Our ref: DOC19/722863
Senders ref: SSD-10154

Subject: EES comments on Response to Submissions for Qantas Flight Training Centre – SSD-10154 – 297 King Street, Mascot

Subject: EES comments on Response to Submissions – Qantas Flight Training Centre – SSD-10154 – 297 King Street Mascot

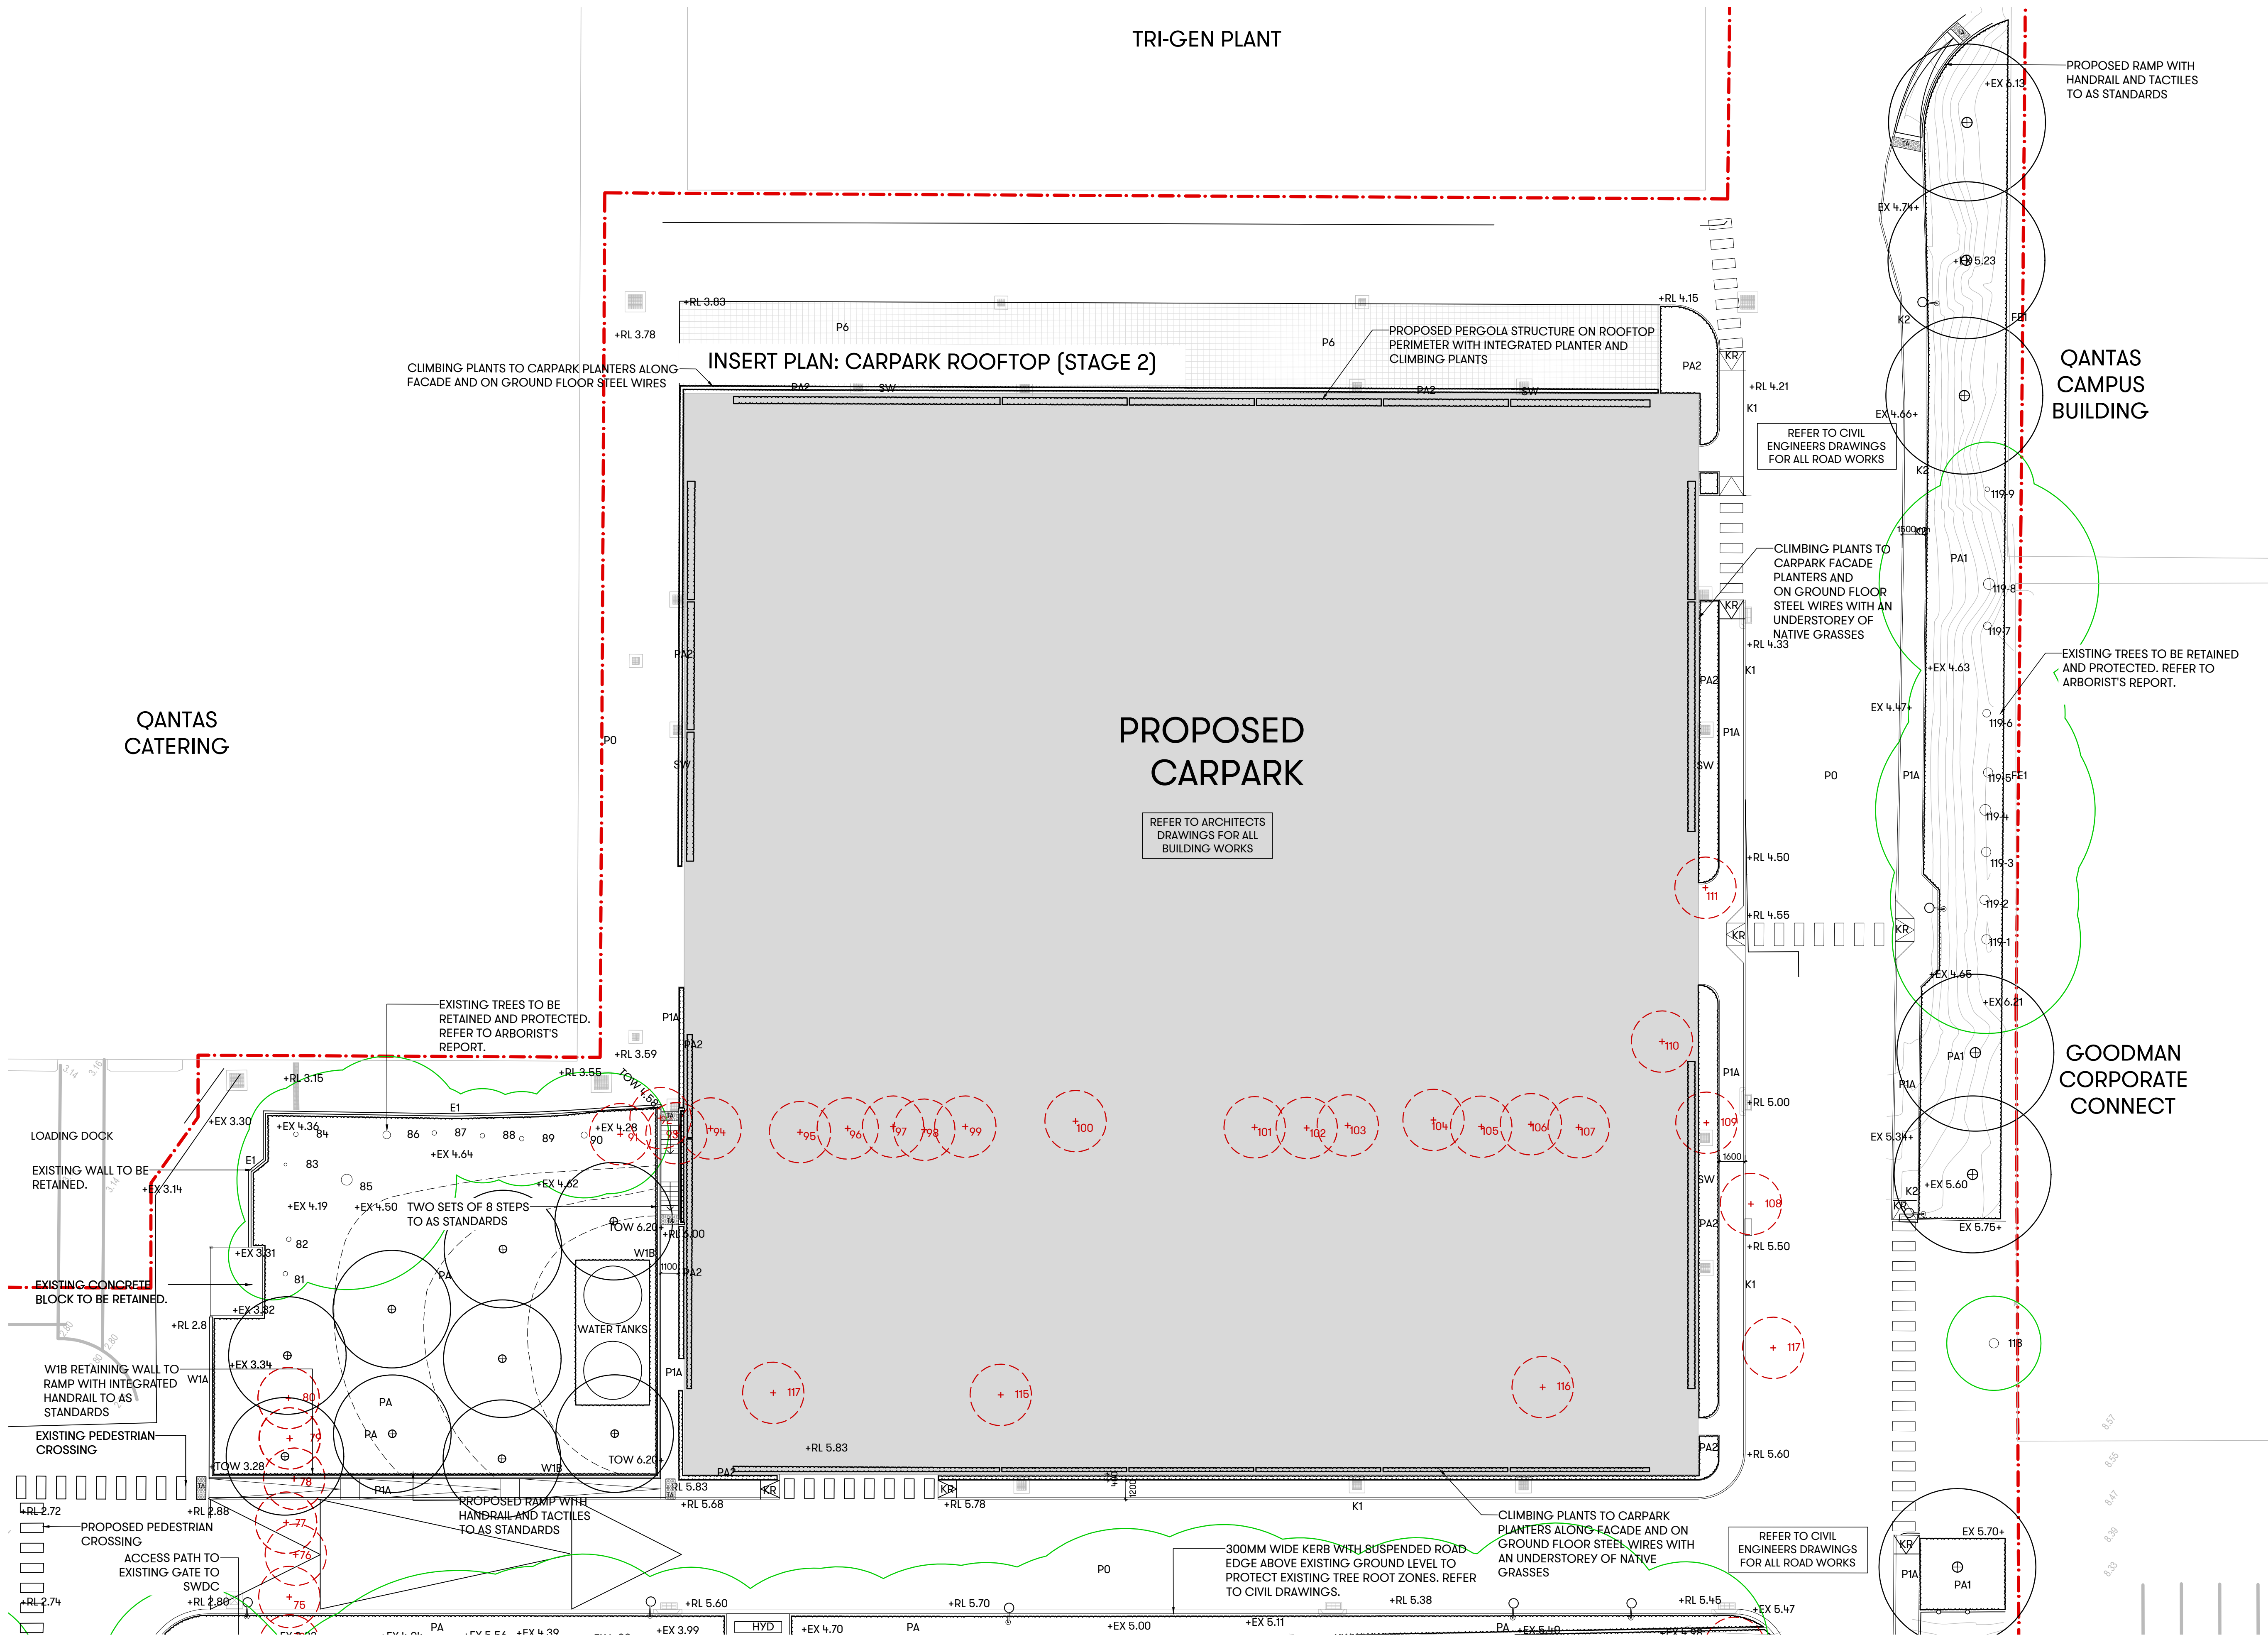
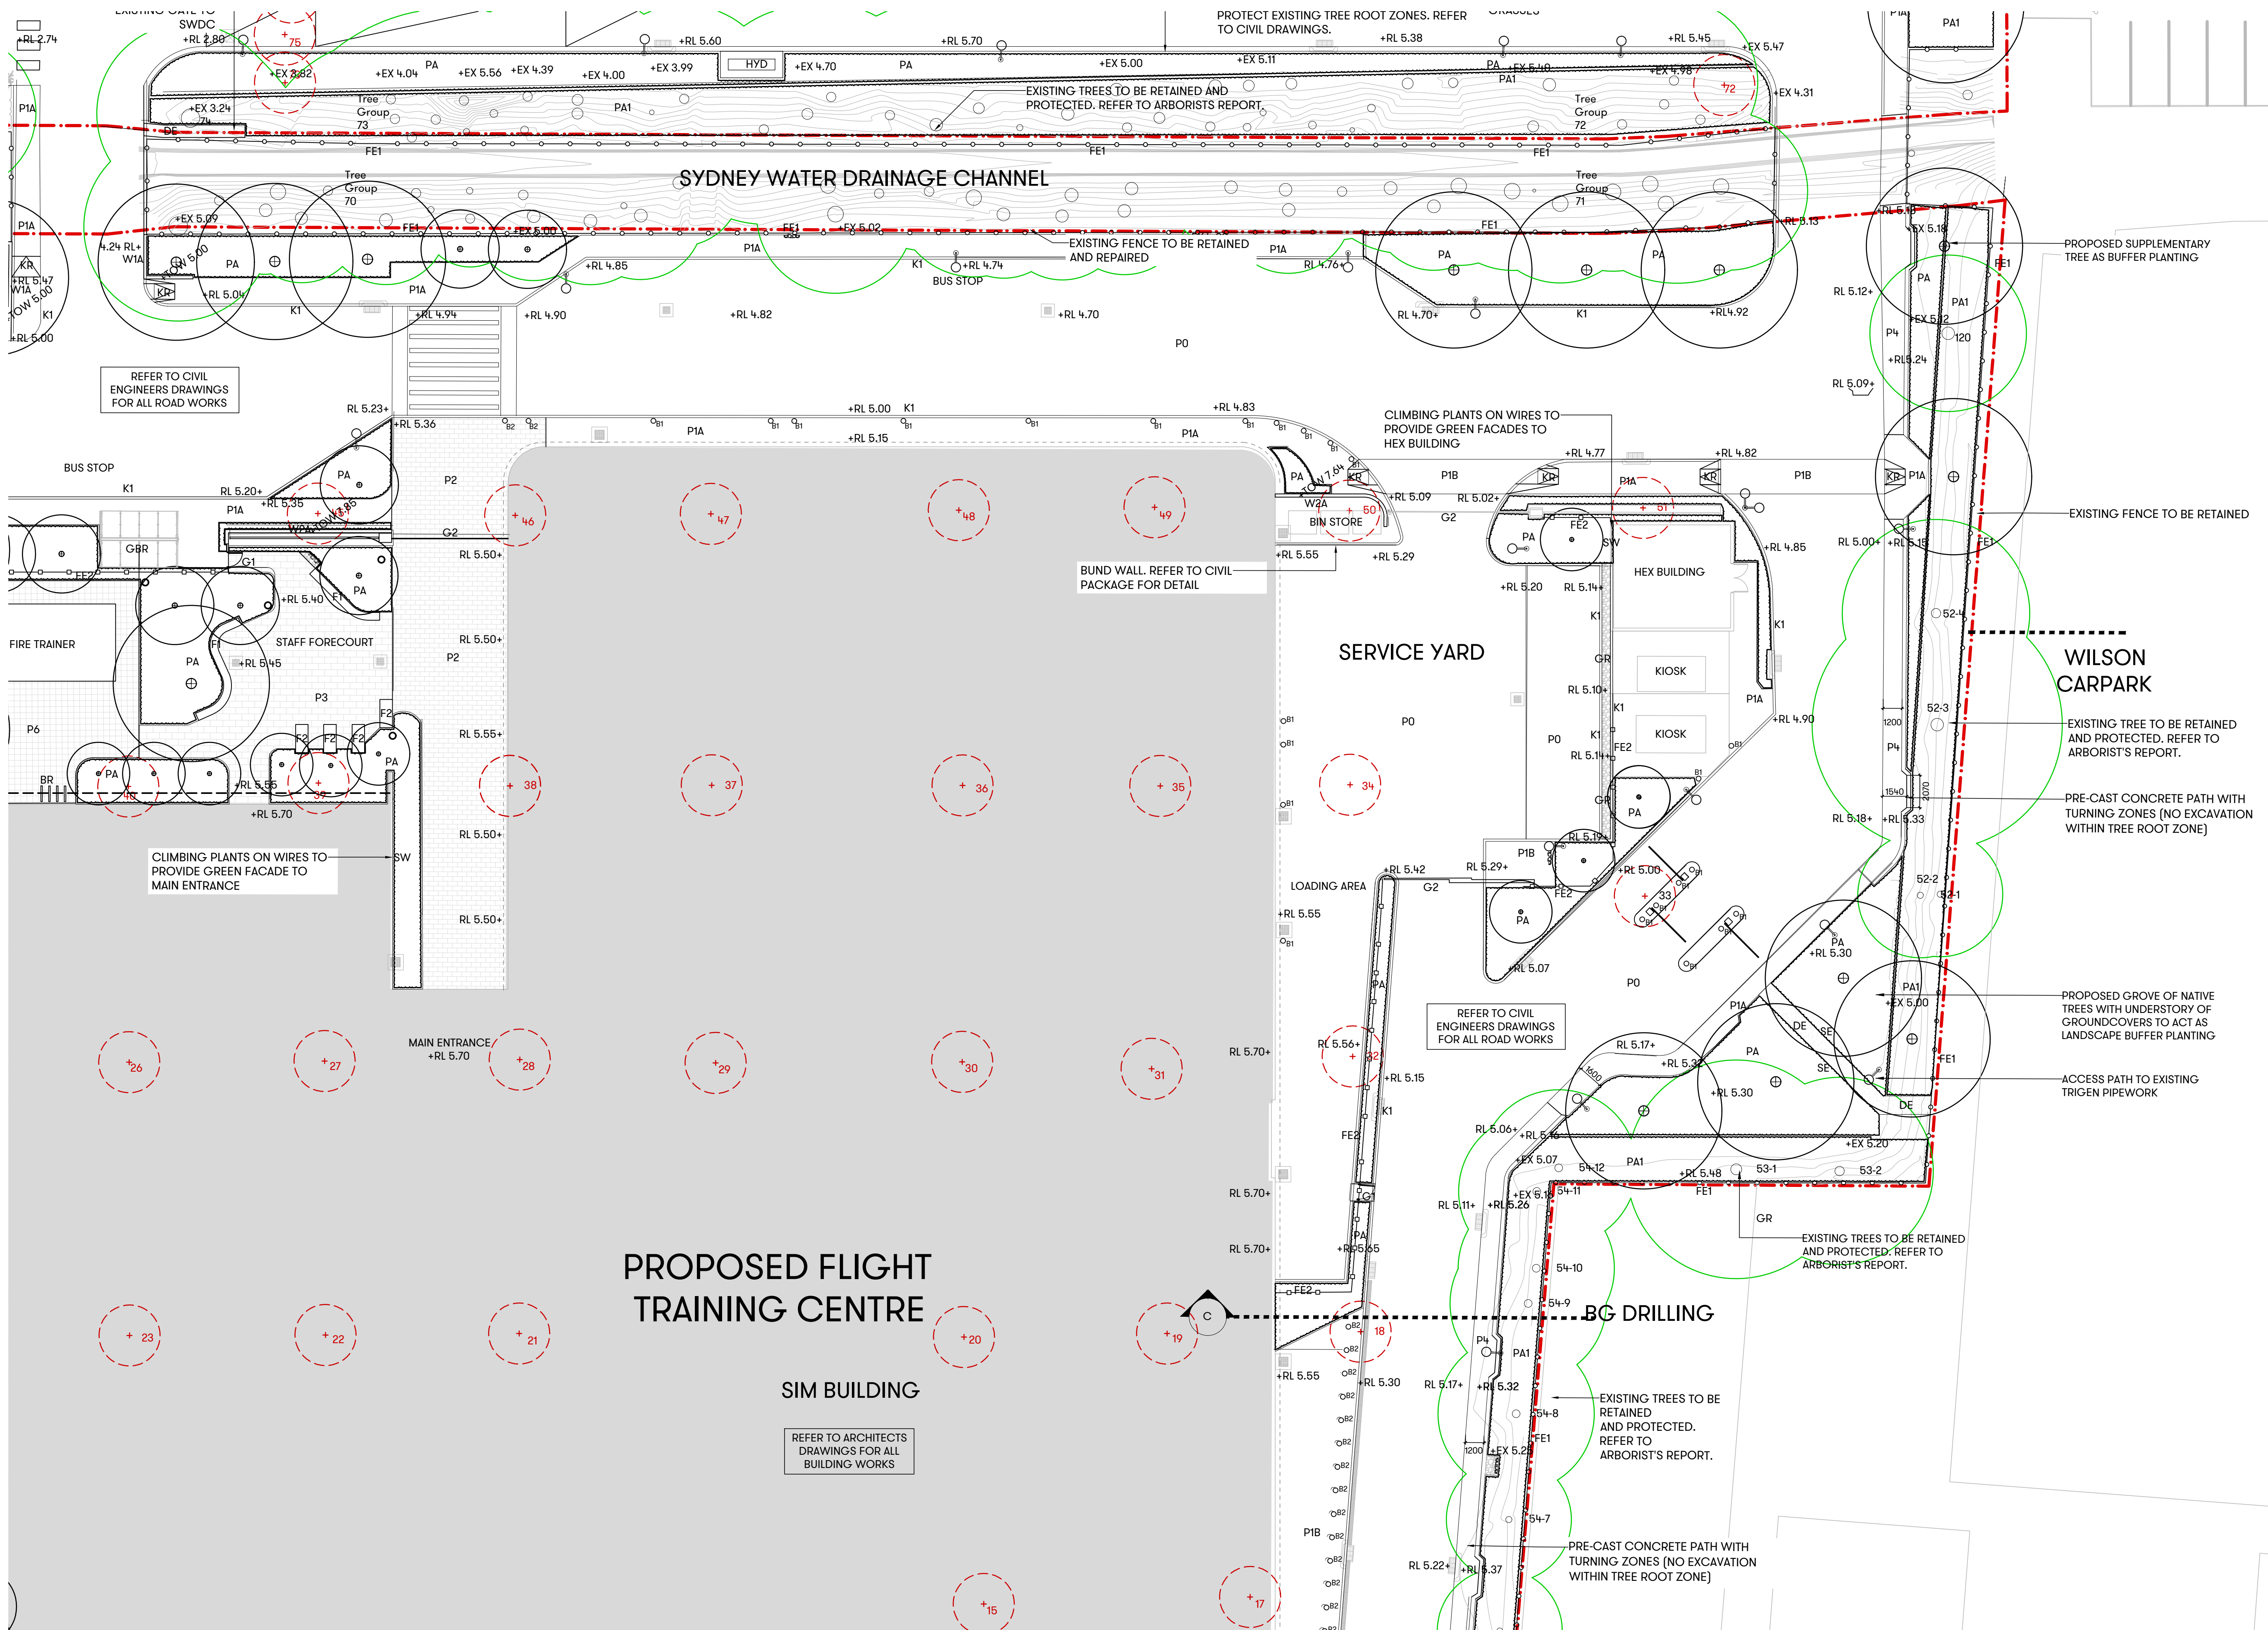
In relation to the first recommendation above that the development first avoids removing the existing trees, it is noted the proposed number of trees to be removed has increased by an additional tree from the removal of 85 trees in the EIS to the removal of 86 trees in the RTS.

In relation to the second recommendation above that any removed trees are replaced at a ratio greater than 1:1, the RTS confirms the landscape plans have been amended to increase the number of replacement trees from 68 trees to 92 trees with a replacement rate of over 1:1 ratio (see pages 2-10, 3-23 and 3-61).

- The RTS notes four *Eucalyptus haemastoma* are proposed to be planted along King street (page 3.34) but the NSW Threatened Species Scientific Committee final determination for ESBS does not list *Eucalyptus haemastoma* as occurring in the ESBS ecological community. Tree species which occur in the ESBS community that could be planted as an alternative include *Angophora costata* and *Corymbia gummifera*.

As the RTS indicates that ESBS once occurred on the site, EES encourages a greater use of ESBS plant species where available. The NSW Threatened Species Scientific Committee final determination for this critically endangered ecological community includes a list of ESBS species: www.environment.nsw.gov.au/resources/threatenedspecies/determinations/FDESBSCEECC.pdf.

- all replacement trees and landscape species will consist of a diversity of local provenance plant species from the Eastern Suburbs Banksia Scrub in the Sydney Bioregion where available.
